Application for a non-material amendment following a grant of planning permission

2022/62/93868/W
DECISION – Conditional Full Permission
I hereby authorise the approval of this application for the reasons set out in the officer's report and recommendation annexed below in respect of the above matter.
Teresa Harlow
AUTHORISED OFFICER
Date: 26-May-2023
Site Description
477 New Hey Road, Salendine Nook, is a brick semi-detached bungalow with a concrete tiled roof. The property currently shows the internal layout with 2 bedrooms and provides off- street parking for 2 cars with no parking restrictions along the front of the property. The property benefits from a covered seating area and raised decking area to the rear.
Description of Proposal
The application is for the erection of a single storey rear extension and a rear dormer, replacing the existing covered seating area and original outrigger. The proposal would create a larger open plan kitchen/living area, with 2 larger bedrooms and bathroom within the attic space. External alterations include the inclusion of an electric point and 12 solar panels to the rear roof. Internal alterations would include a new staircase to regularize t

Drawing Title
Existing elevations

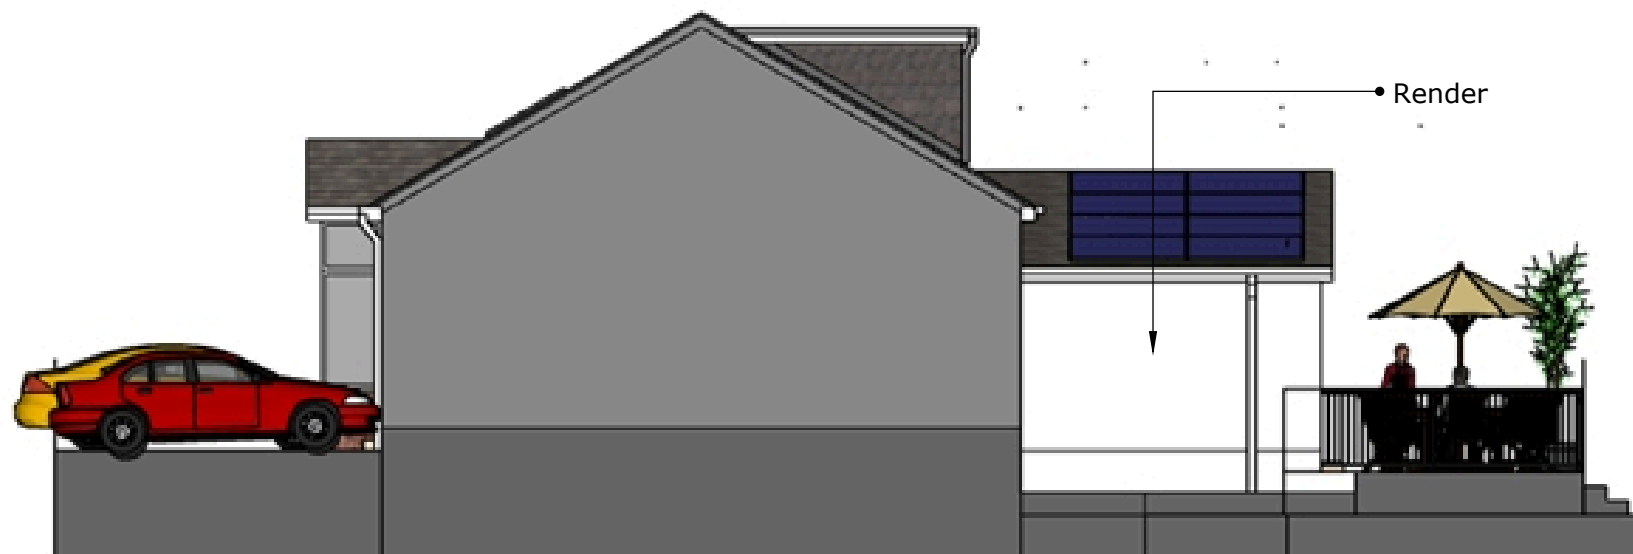
Rear extension changes to the roof and bifold doors:
The amendments consist of converting the existing pitched roof on the rear extension to a flat roof and installing a roof light. This change will not only maintain the building's current height but will also improve natural light in the space.
Adjustment to the kitchen area consists of replacing the two bi-fold doors with a single, expansive 6-meter bi-fold door.
